A585 Windy Harbour to Skippool Improvement Scheme

TR010035

7.11 Environmental Statement Changes and Corrections Document

July 2019

VIEWPOINT 10 PHOTOMONTAGE: YEAR 1

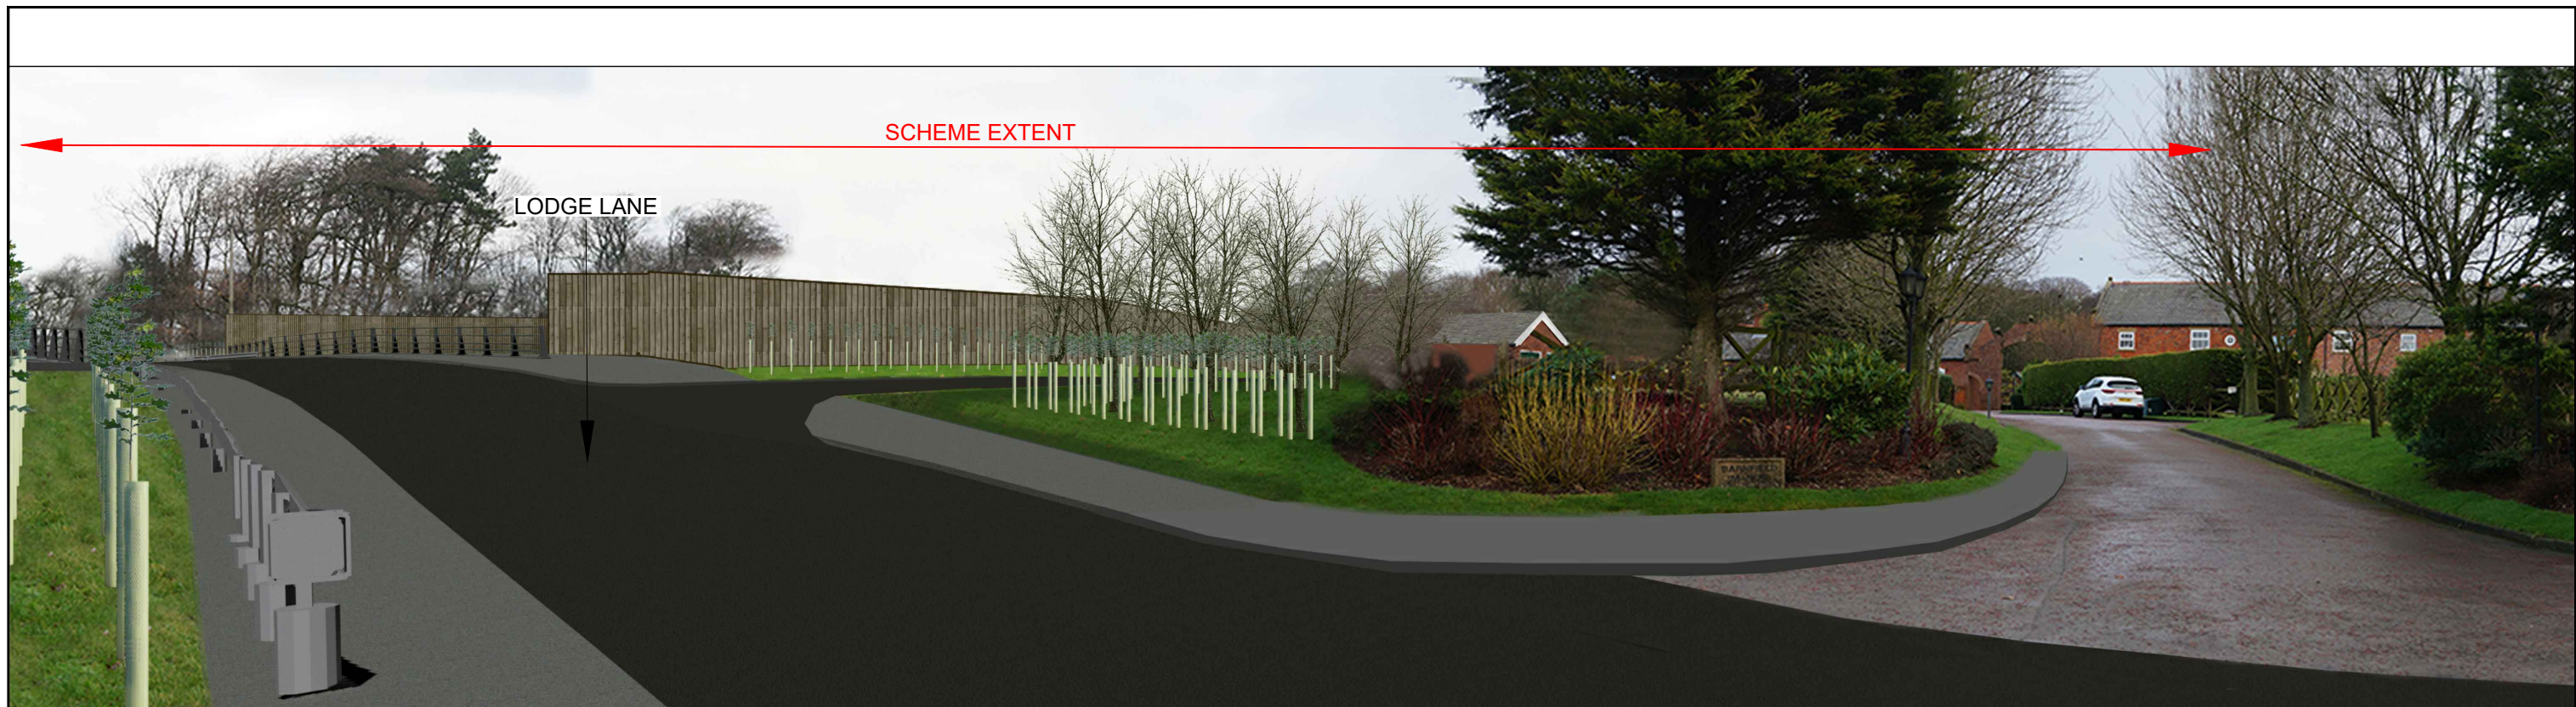
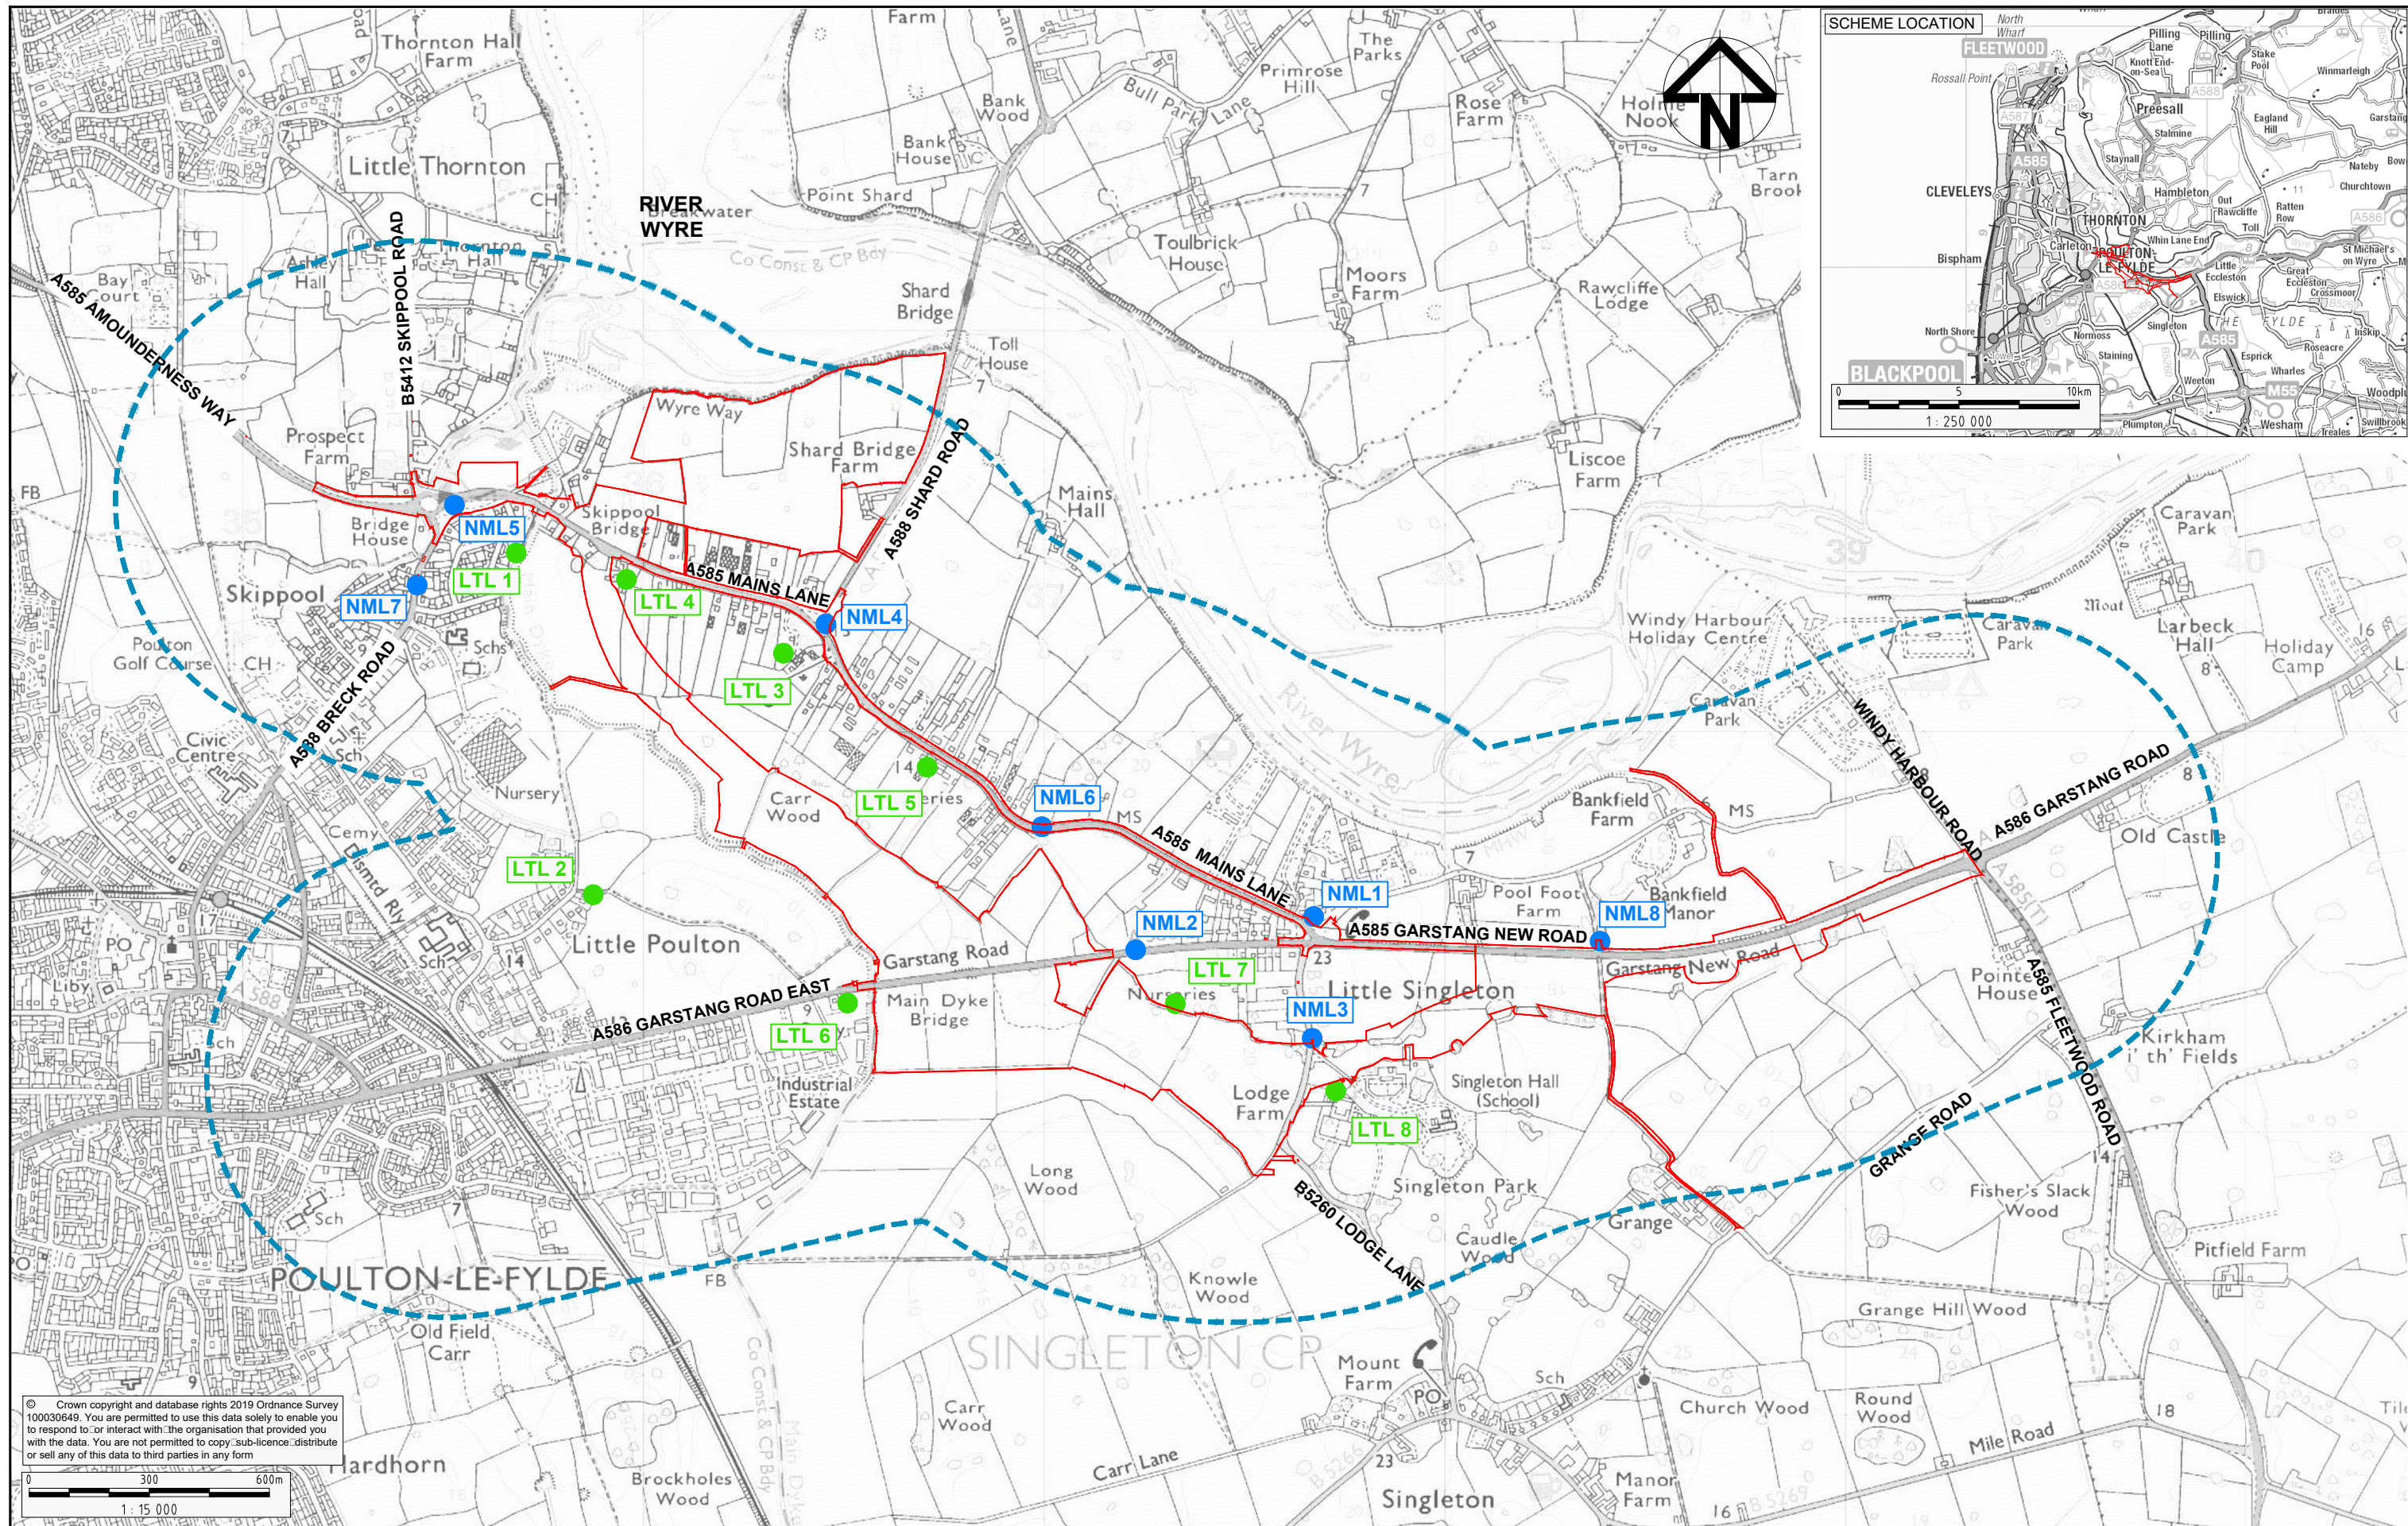
Document Reference Number	Document Name	Amendment Required	Reason									
6.9	ES Chapter 9: Landscape	Update to Figure 9.10, Photomontage at viewpoint location 2, view from residential properties on Breck Road provided within Appendix C.	As a result of updates to the Flood Risk Assessment associated with the dwarf wall.									
6.9	ES Chapter 9: Landscape	Update to Figure 9.10, Photomontage at viewpoint location 10, view from the B5260 Lodge Lane provided within Appendix C.	Updated to show the 3m high acoustic barrier to the north of the cutting.									
6.9	ES Chapter 9: Landscape	Update to Figure 9.10, Photomontage at viewpoint location 9, view from the A585 Garstang New Road provided within Appendix C.	Updated to show the additional linear planting adjacent to Grange Footbridge, as a result of request from Fylde Borough Council (document reference TR010035/APP/7.9).									
6.9	ES Chapter 9: Landscape	Update to Table 9-16

APPENDIX D – Updated Figure 11.1: Noise and Vibration – Noise Monitoring within the Study Area and Figure 11.4: Noise and Vibration – Noise Mitigation

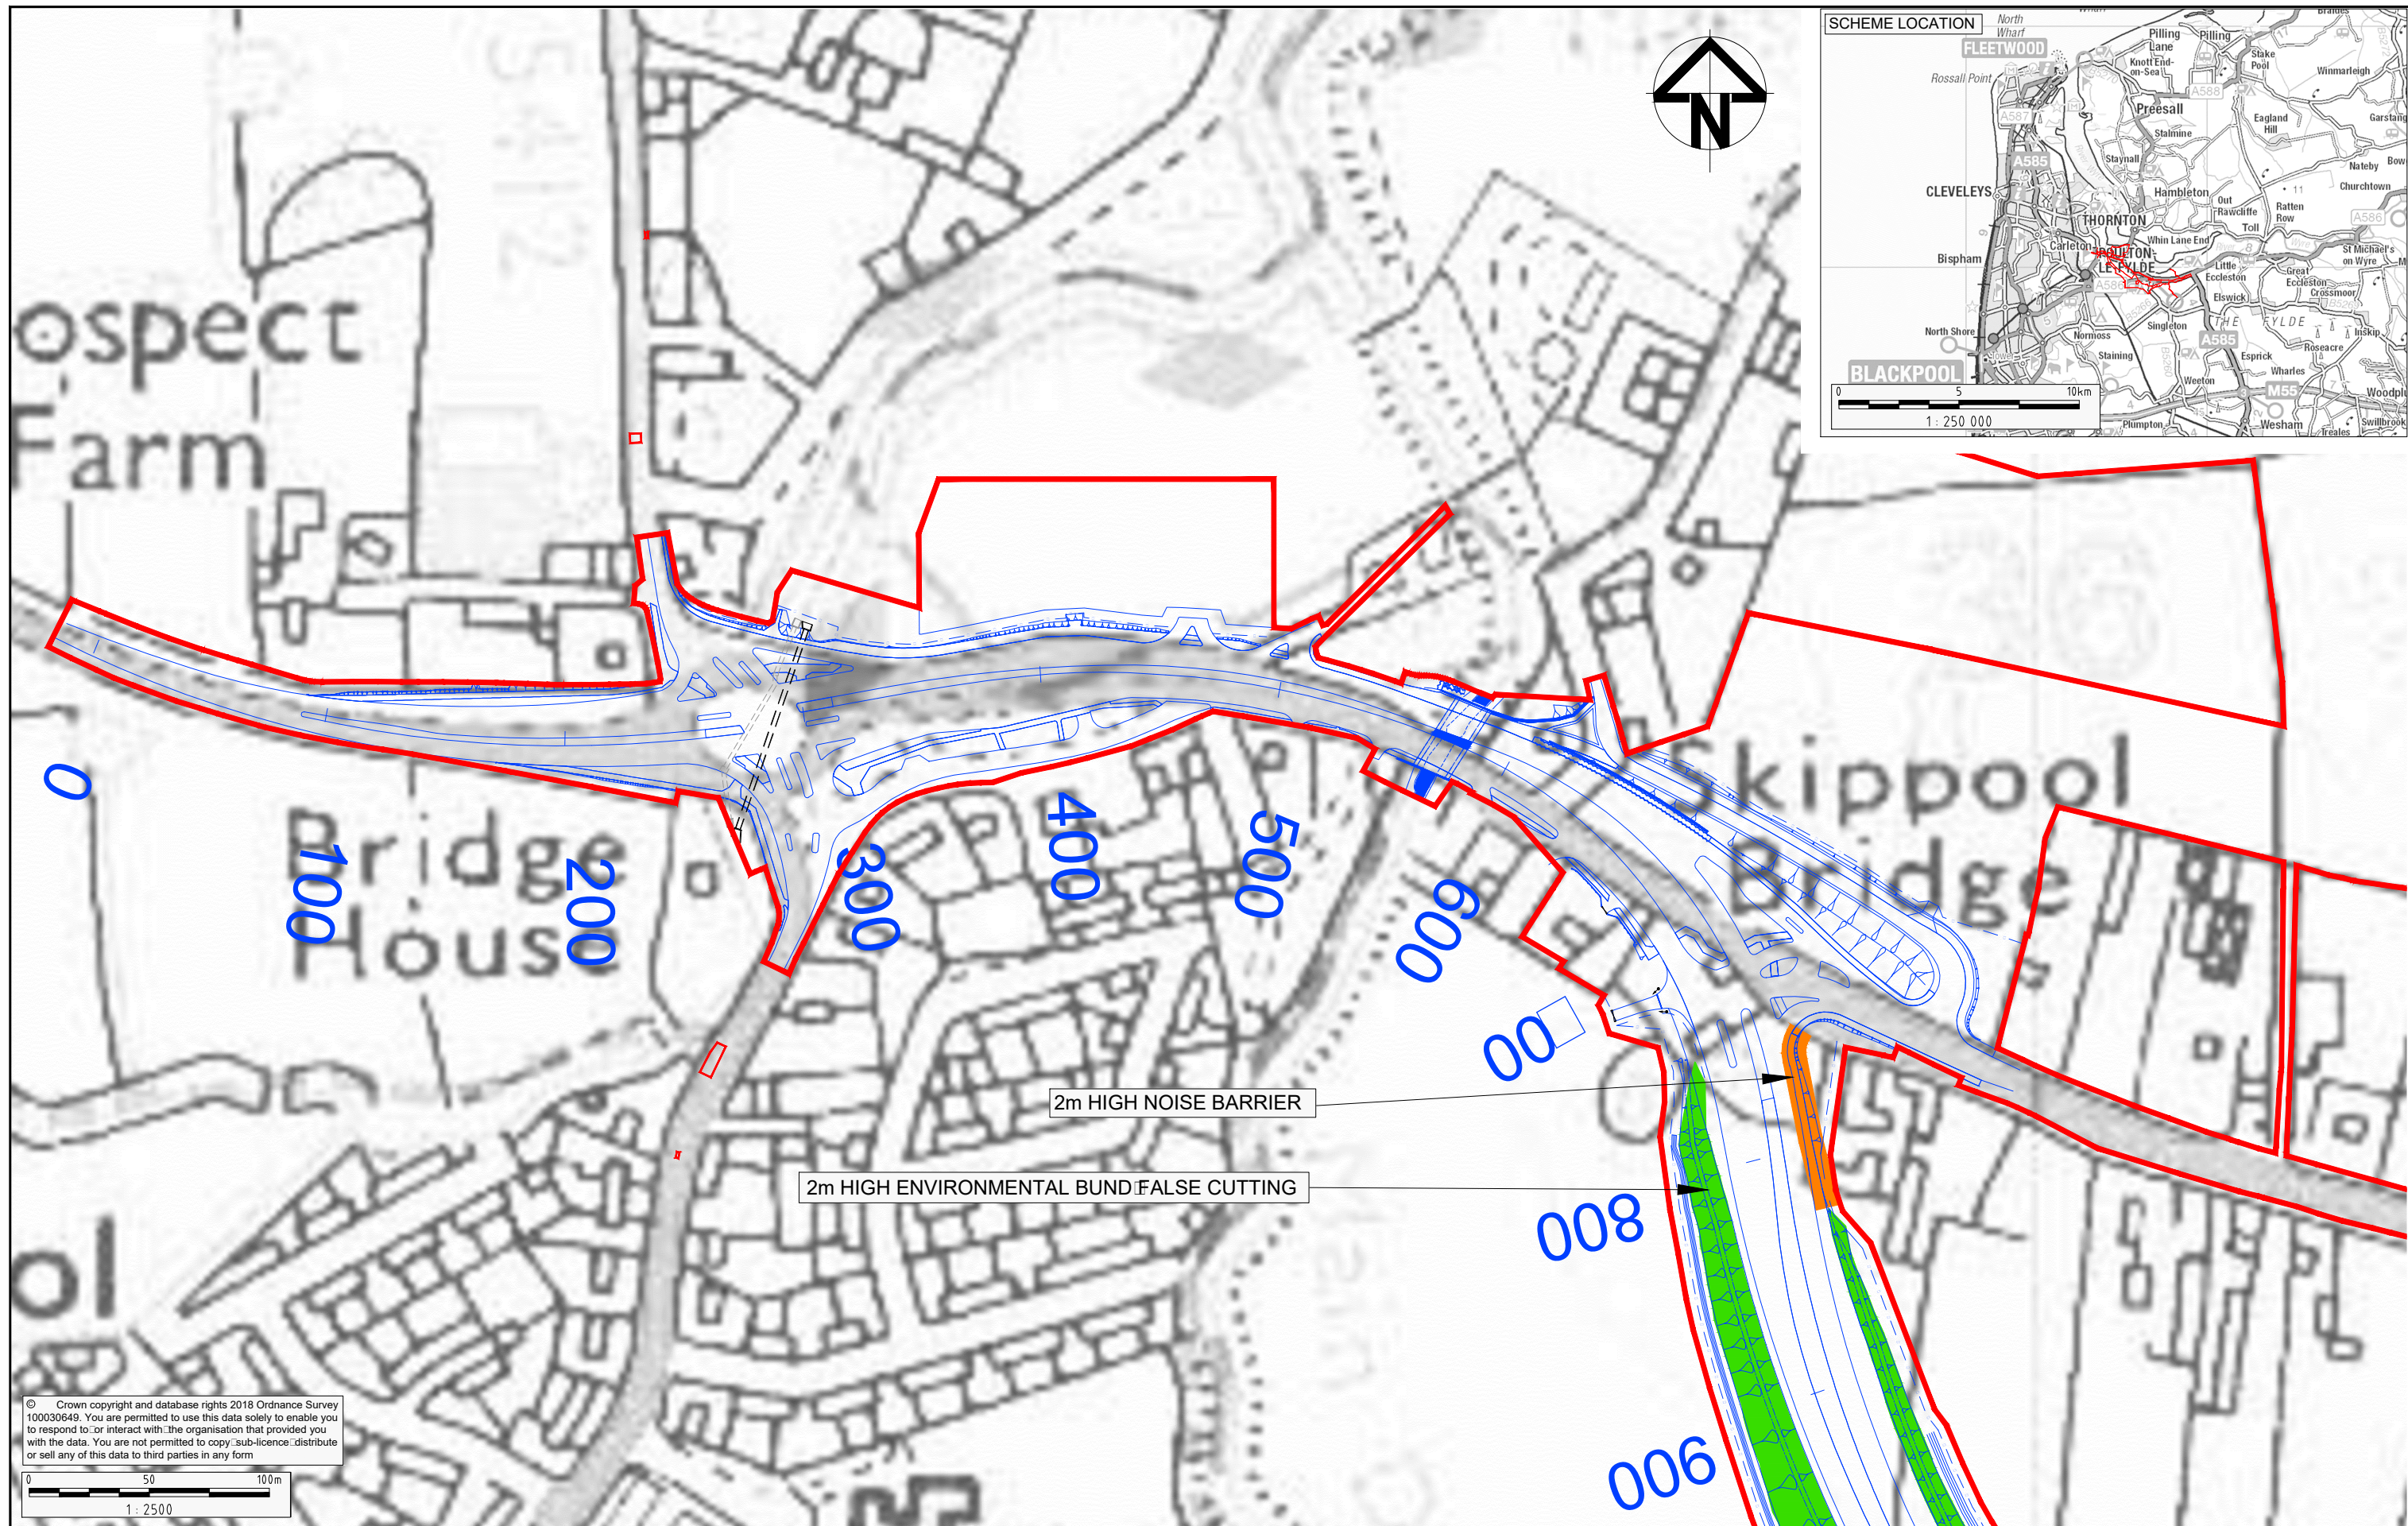
6.11	ES Chapter 11: Noise and Vibration	Update to Figure 11.1: Noise and Vibration – Noise Monitoring within the Study Area presented at Appendix D to show the locations of the eight attended noise surveys.	Requested by the Inspector within the first round of written questions (document reference
